From: Sue Howell
Sent: 24 July 2014 12:21
To: Planning.Responses
Cc: Cian Cronin
Subject: RE: Planning Consultation on: BE/73/14/PL

APPLICATION BE/73/14/PL

Site Address: Land at Oldlands Farm Shripney Road Bognor
Regis PO22 9NN

Description of Works: Erection of 2 No. detached industrial/distribution units (B1(c)/B2/B8) including access & servicing arrangements, car parking, landscaping & associated flood compensation area. This application is a departure from the development plan. This application also lies within the parish of Aldingbourne

- DLA-1606-L02-02 Hard Landscape Layout
- DLA-1606-L02-03 Planting proposals

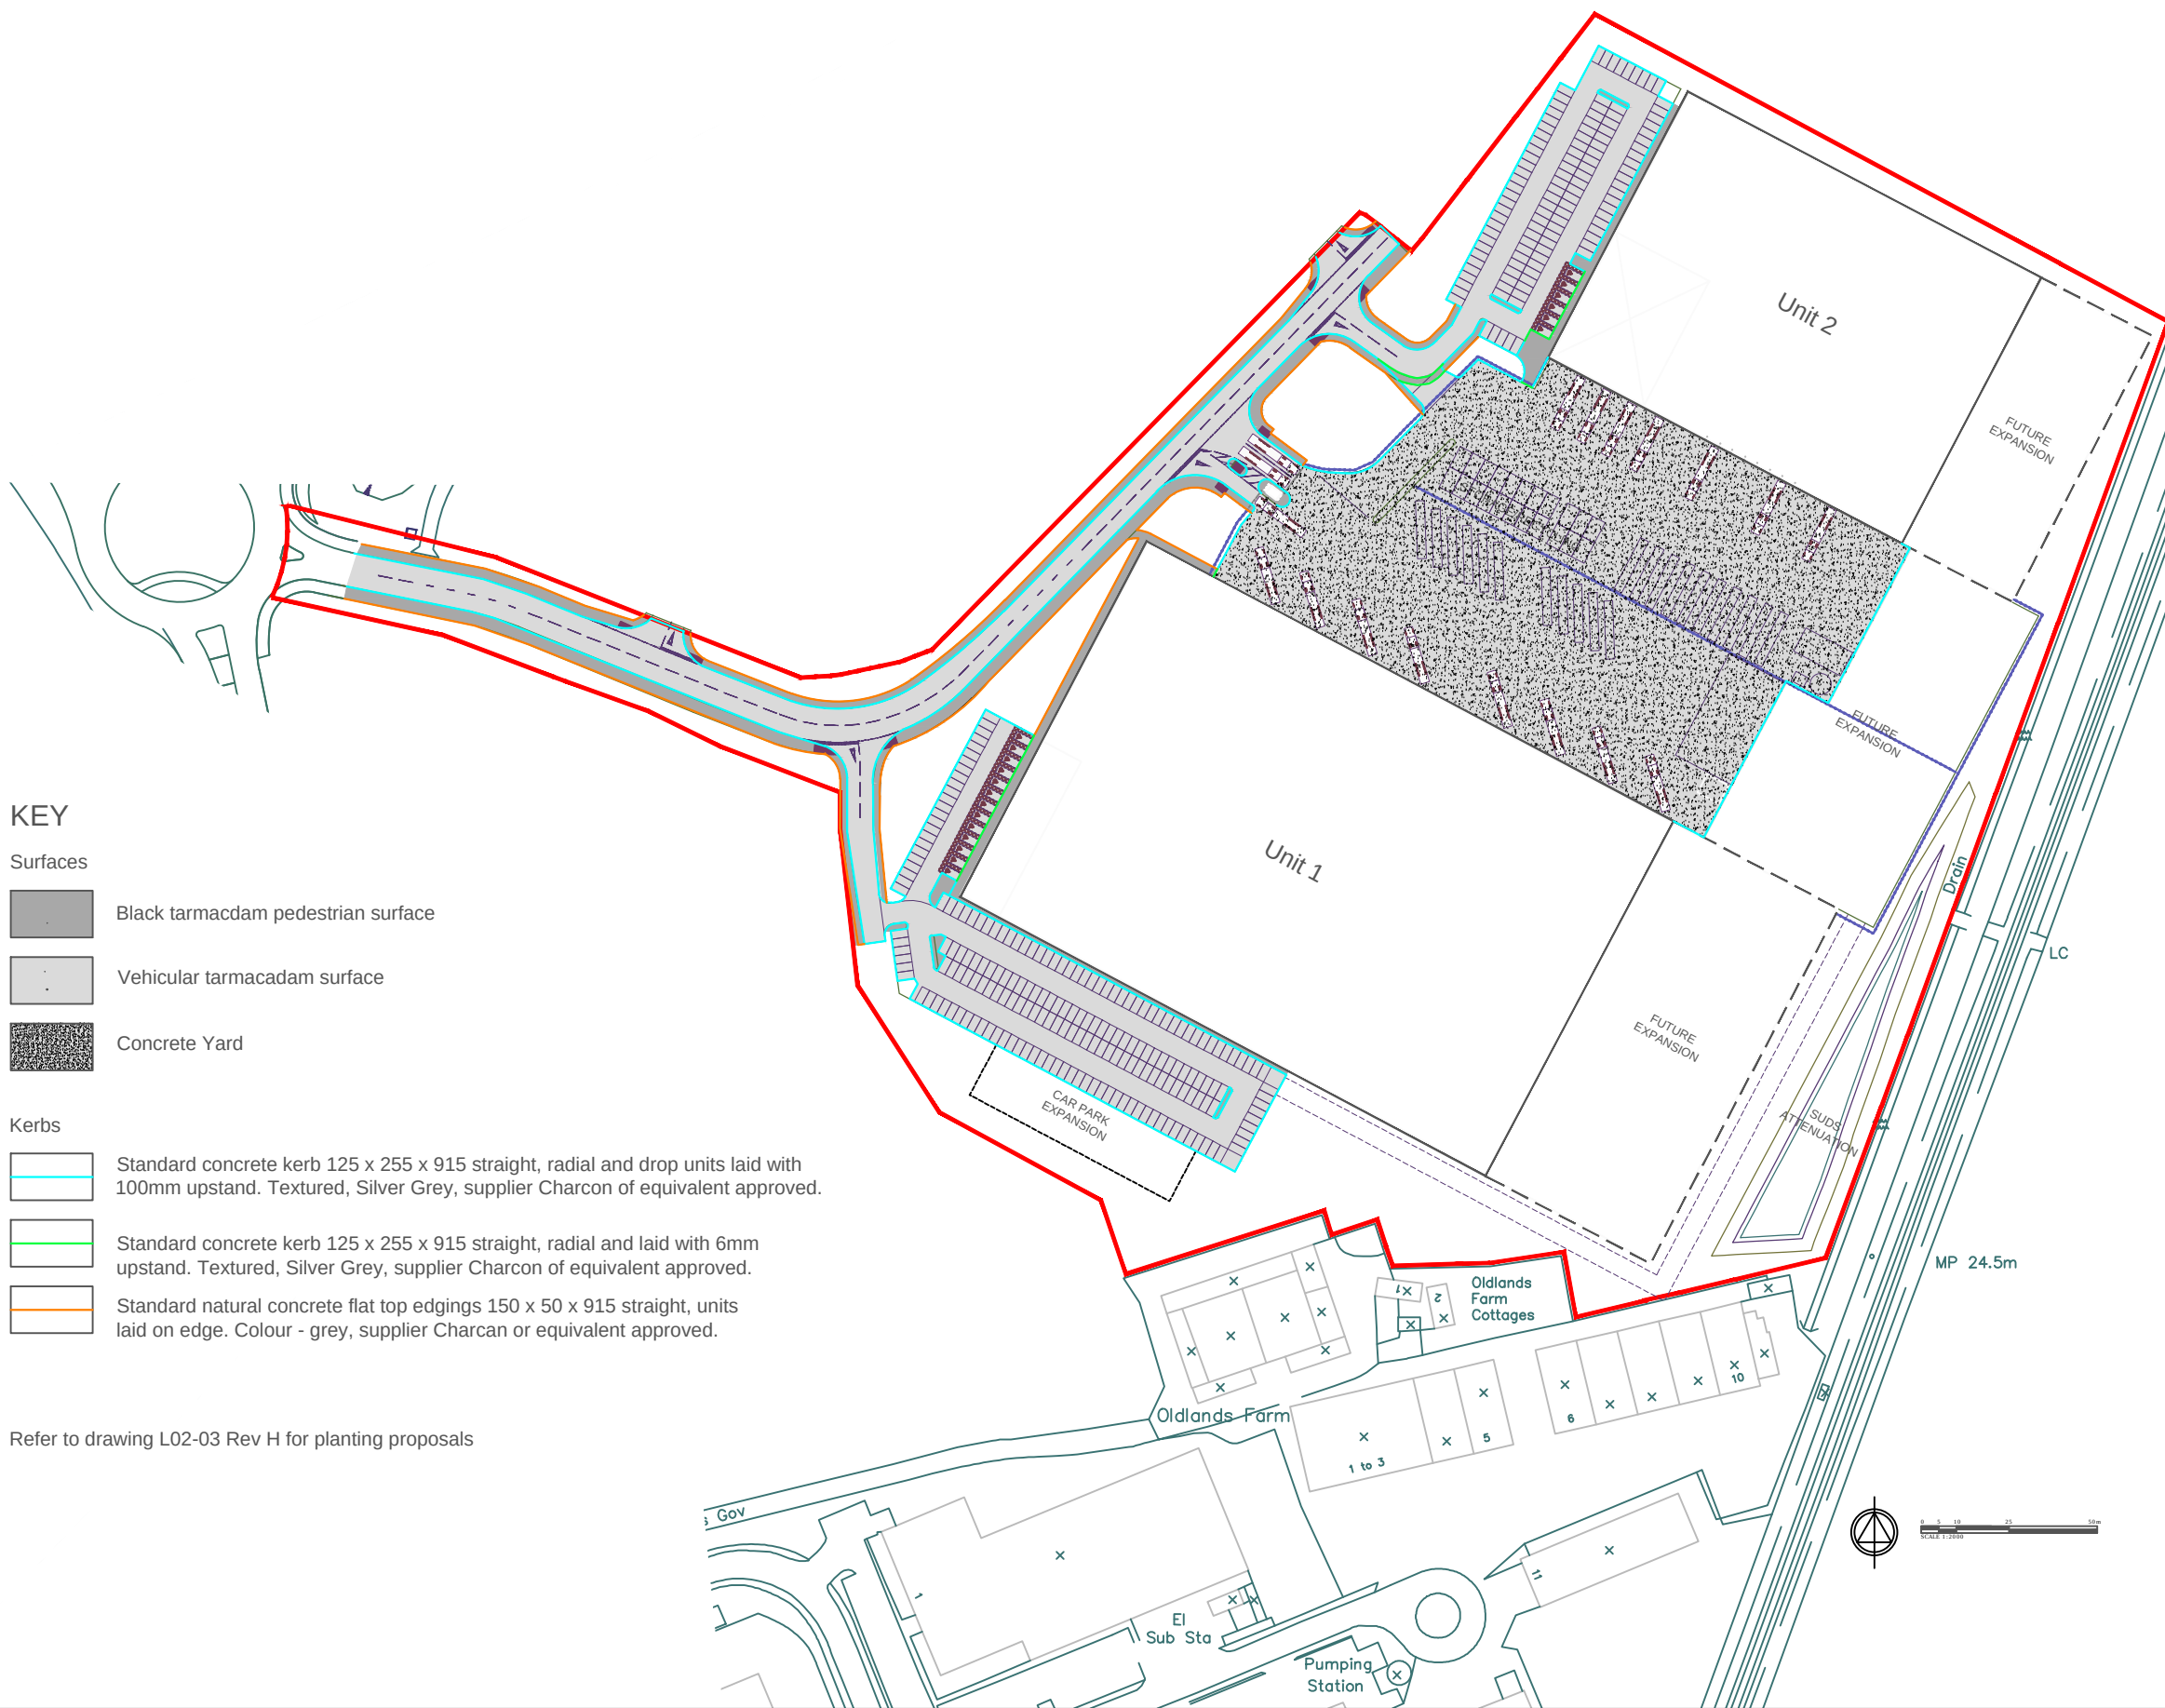
A detailed Landscape Visual Impact Assessment has been submitted with the application ensuring consideration has been given to the landscape impact and that any mitigation requirements will be reflected in the design of the scheme. However this references indicative master plans and the tree species indicated in 5.4.2 table 7 differs from that shown on Fig 02 Landscape soft works. Dwg 1606-LO2-02 ref F and -30 Rev C are vague and lacking in the detail required, requirement as detailed below

Forming part of the application and prior to any consent being given a full landscape scheme should be submitted for approval, detailing species choice, position, densities and size at time of planting. This should be plotted in plan and list form and in relation to the trees and vegetation to be retained in the locale, so that a clear picture of the proposals can be seen. These details are required to assure the adjacent land setting is maintained, the setting is uncompromised and the proposals are appropriate to its setting.
